From: Ian Chappell <[REDACTED]>
Sent: 16 August 2019 13:01
To: Sian Eggington
Subject: Re: FW: LU/231/19/HH
Attachments: We sent you safe versions of your files; TQRQM19227194522880(1).pdf

# Proposed driveway 88 Southfield Road

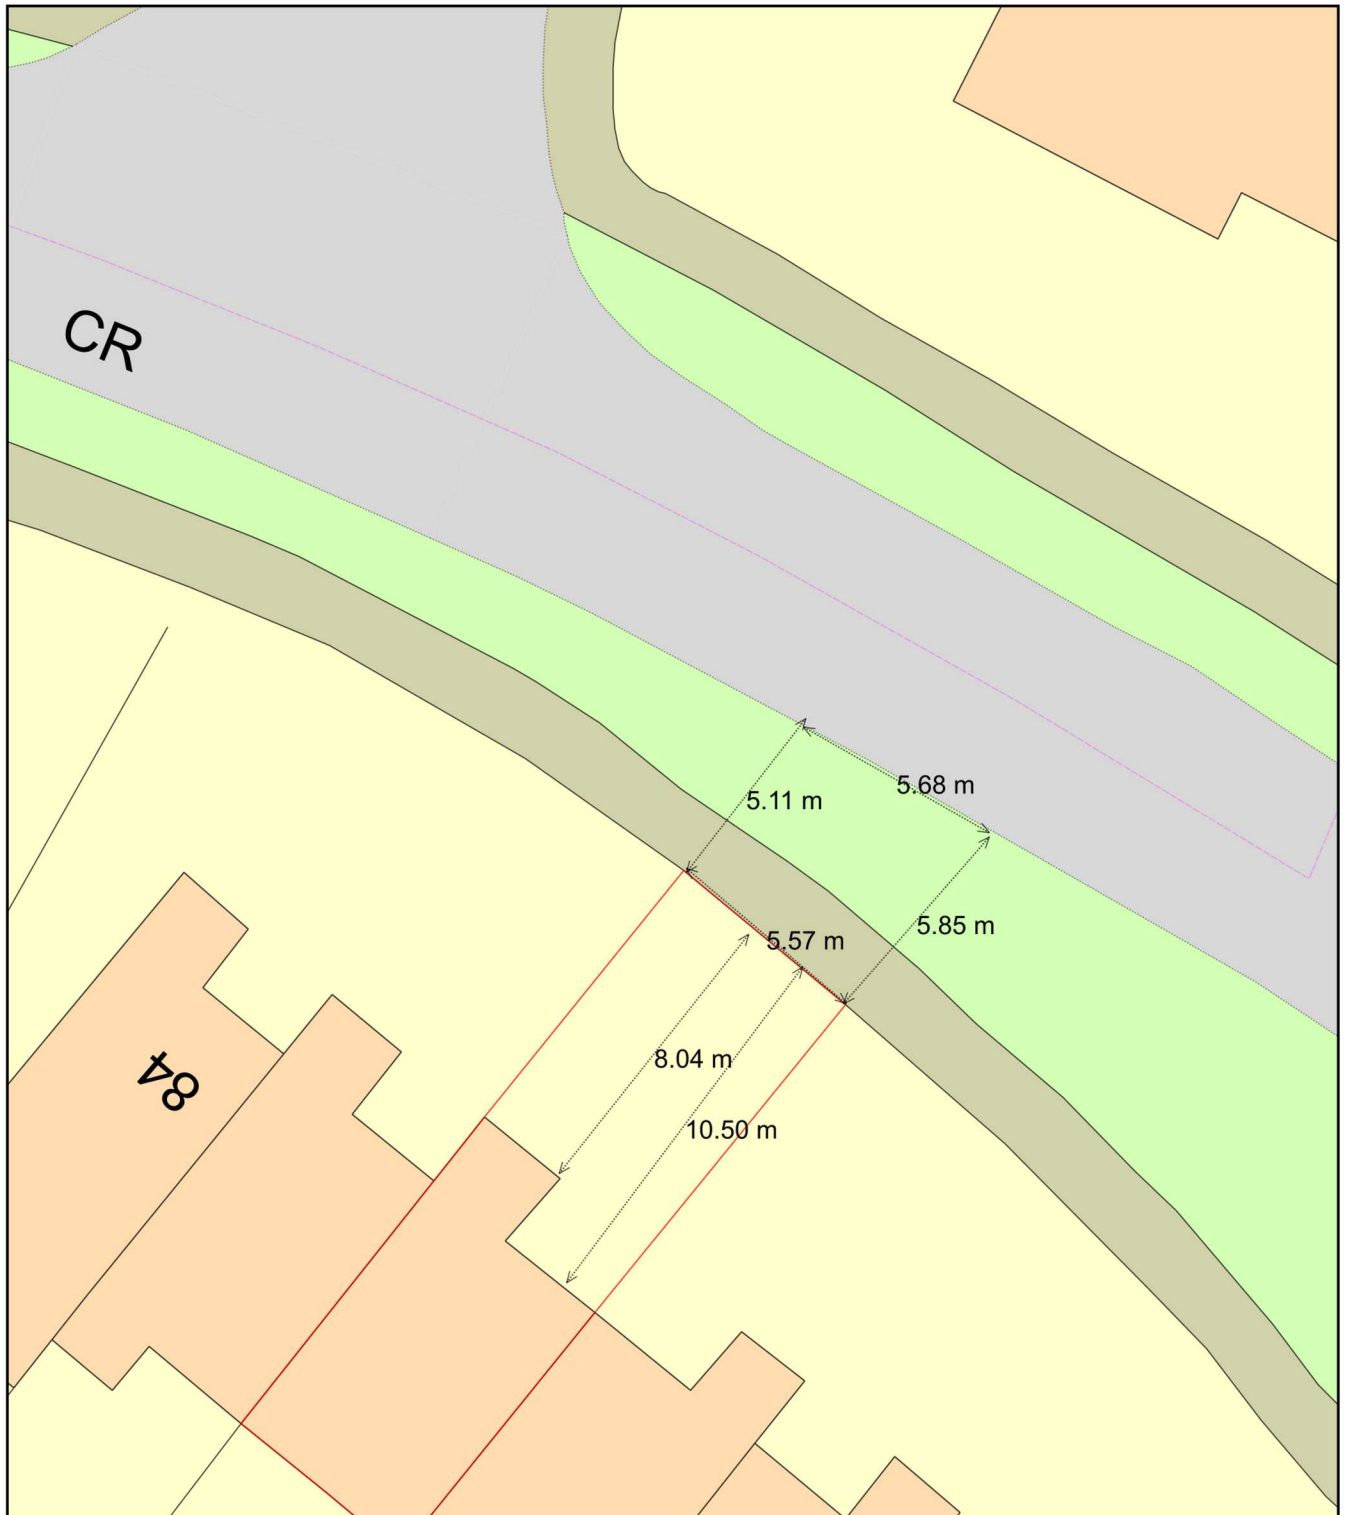
Thank you for your emails, I have forwarded your receipt onto Arun no further fee will be needed. The plans you have submitted are fine however a splay plan is still required. Also on the splay plan if you are able to roughly draw on the car parking spaces onto the driveway i.e a 2 car drive 2 spaces ect then that should be fine. Please confirm I am able to amend the form to read 'yes' to Q8.

A visibility splay is formed by measuring to a point 2.4m back from the carriageway in the centre of the driveway or entrance. A line (70m long in the case of a 30mph limit) is then drawn to the right, to a point where it strikes the near-side edge of the carriageway.

I have added a splay plan (please see attached) to the application but when I try to submit it is still asking for payment. With regards to the area of the drive it would be my intention to convert the whole front garden area to the drive so I think it would easily get 3 cars on it.
